Clifton Villa
37 Hall Cliffe Road
Horbury
Wakefield
West Yorkshire
WF4 6BY
Tel. 0113 2175175 & 01924 270619
Info@treecareconsultancy.co.uk
Our Ref: TCC-2559-1
22 May 2026

Sycamore T5 -11 Wood Street Skelmanthorpe

As instructed, in response to the Arboricultural Officer email of 2 April 2026 I have reviewed the "Methodology for Boundary Wall Works" and the recommendations made by OEC Ltd Structural Engineers, and would comment as follows.

Drawing Title:
Tree Protection Plan

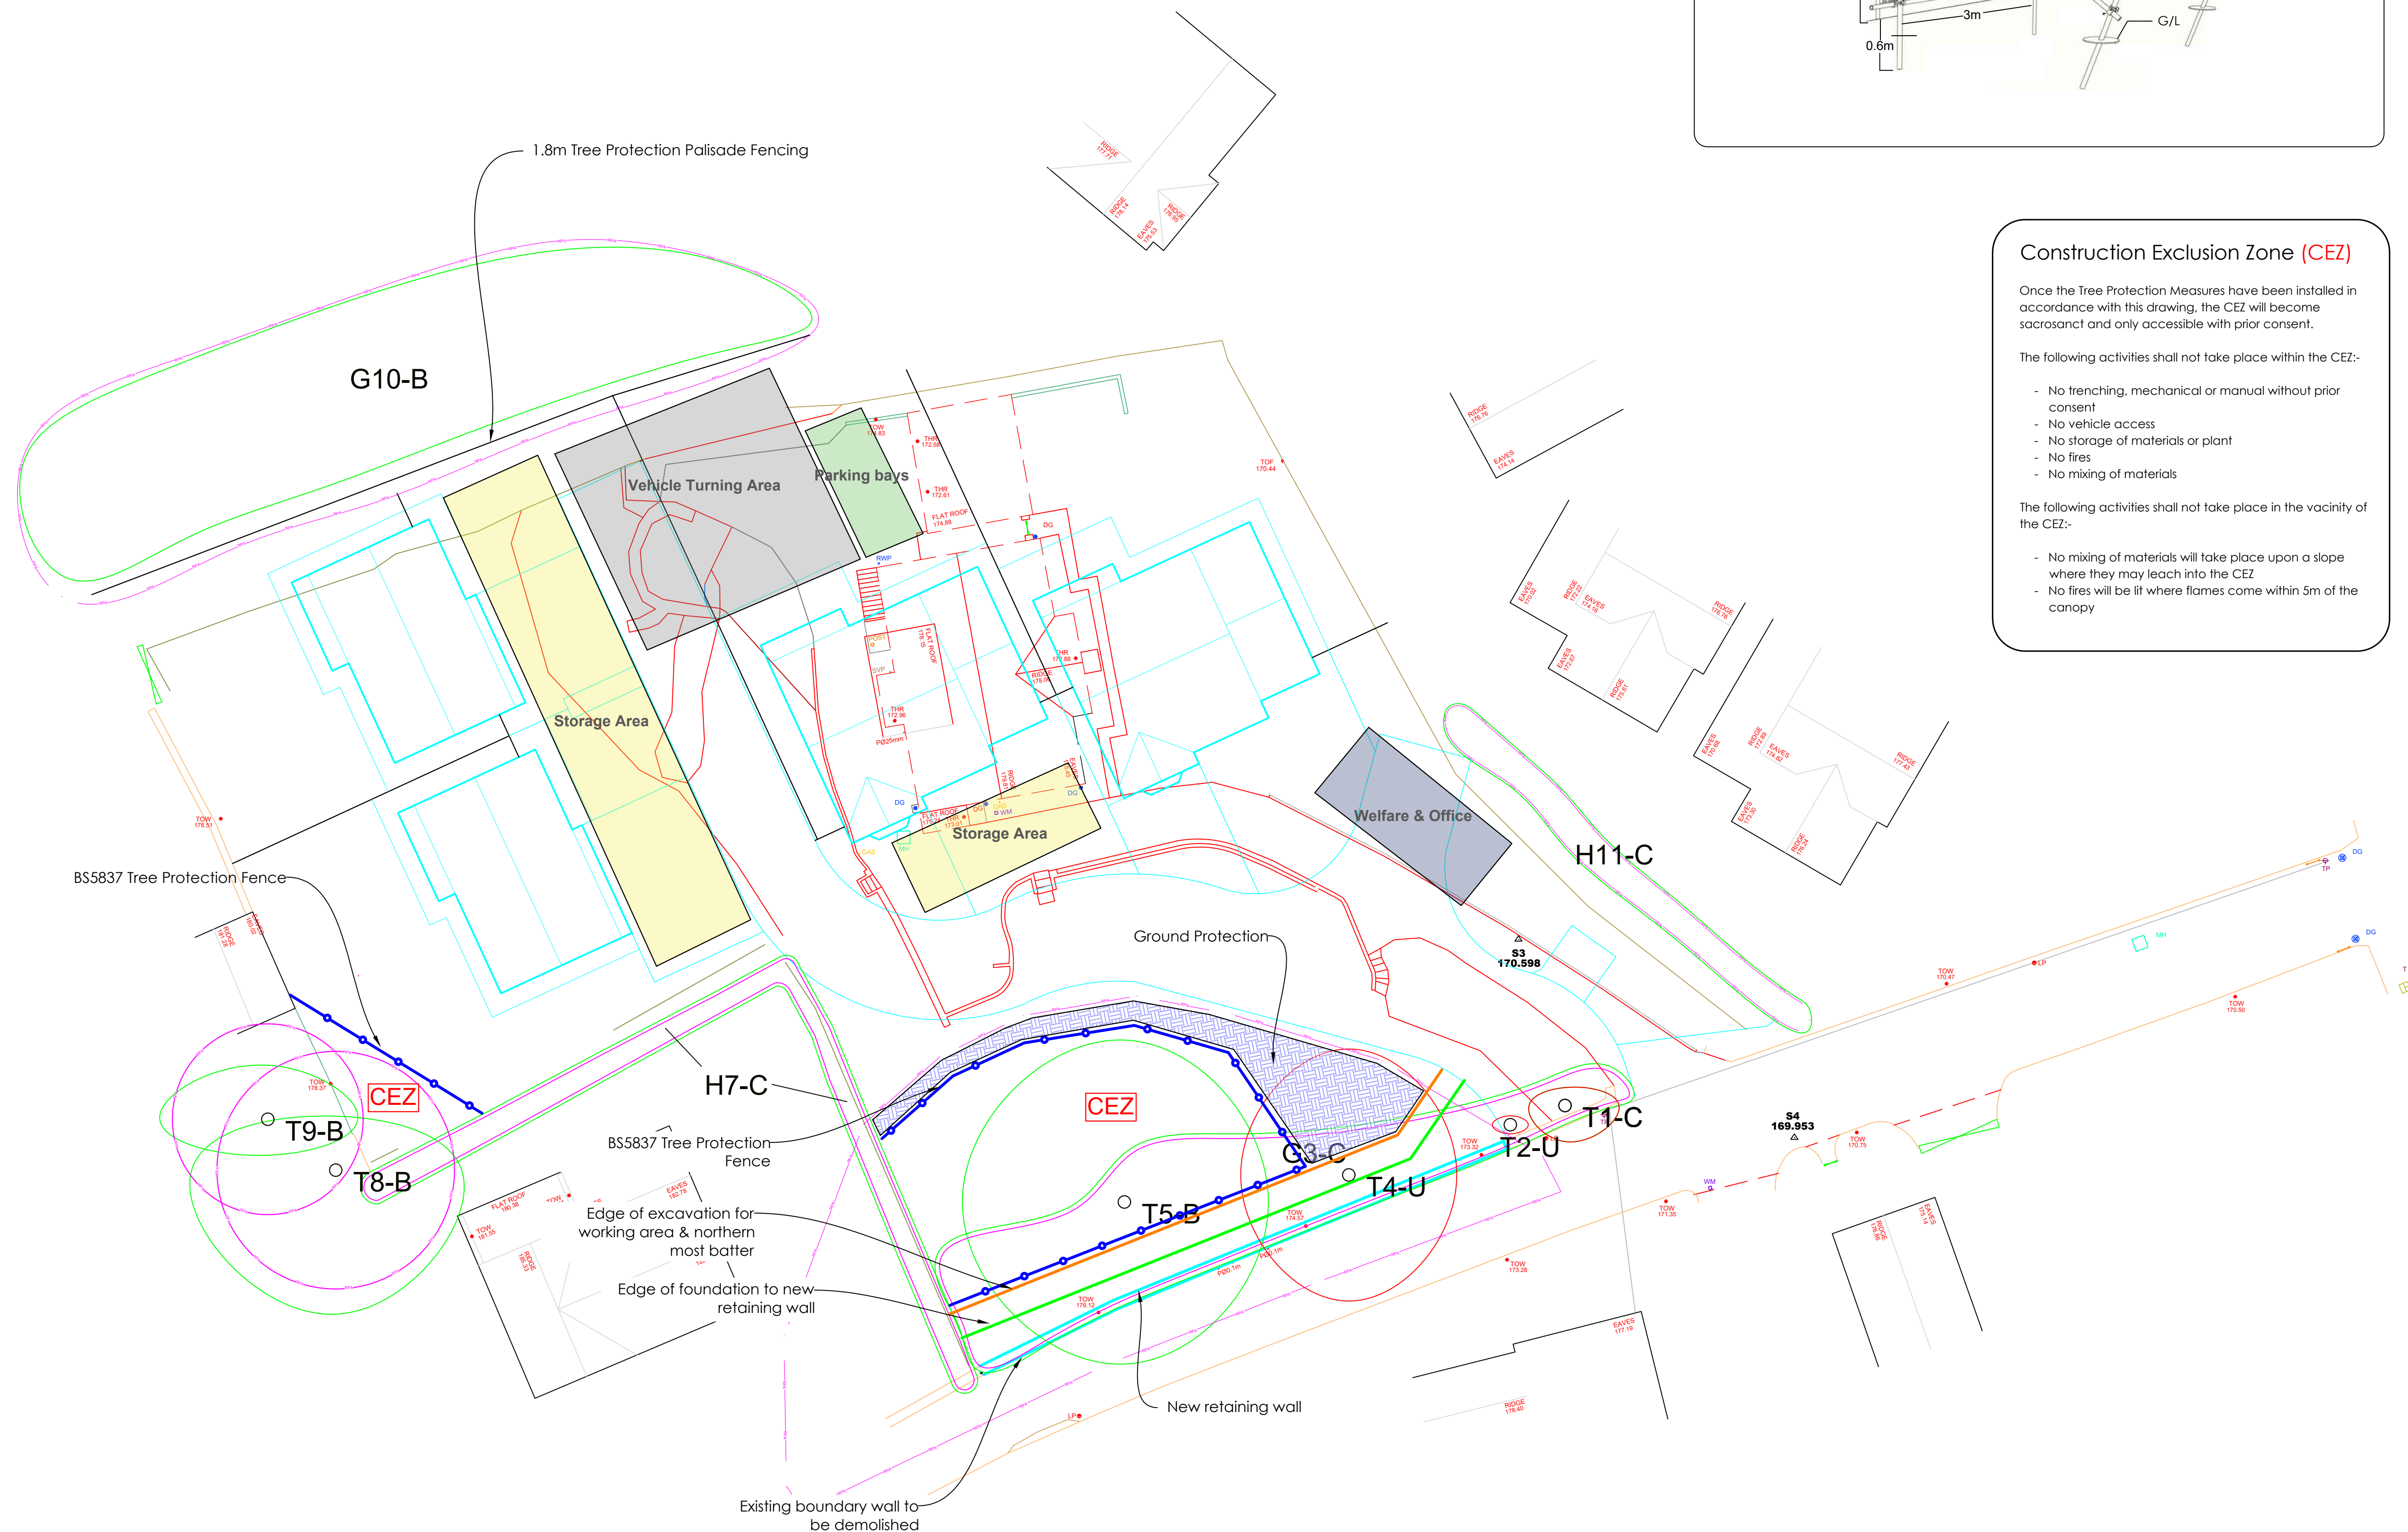
With regards to the Arboricultural Officer's request that you must re-align the tree protection fence to safeguard the entire RPA of T5, for the reasons identified in Linfit Developments Ltd submission, the practicalities require a safe working area between the current line of Tree Protection Fencing in order to facilitate a tracked excavator sufficient to safely implement the approved demolition and rebuild. As such, if T5 is to be retained I recommend the LPA accept the current recommendations detailed in the AMS inclusive of the aforementioned monitoring whilst works are in progress and that matters are kept under review.
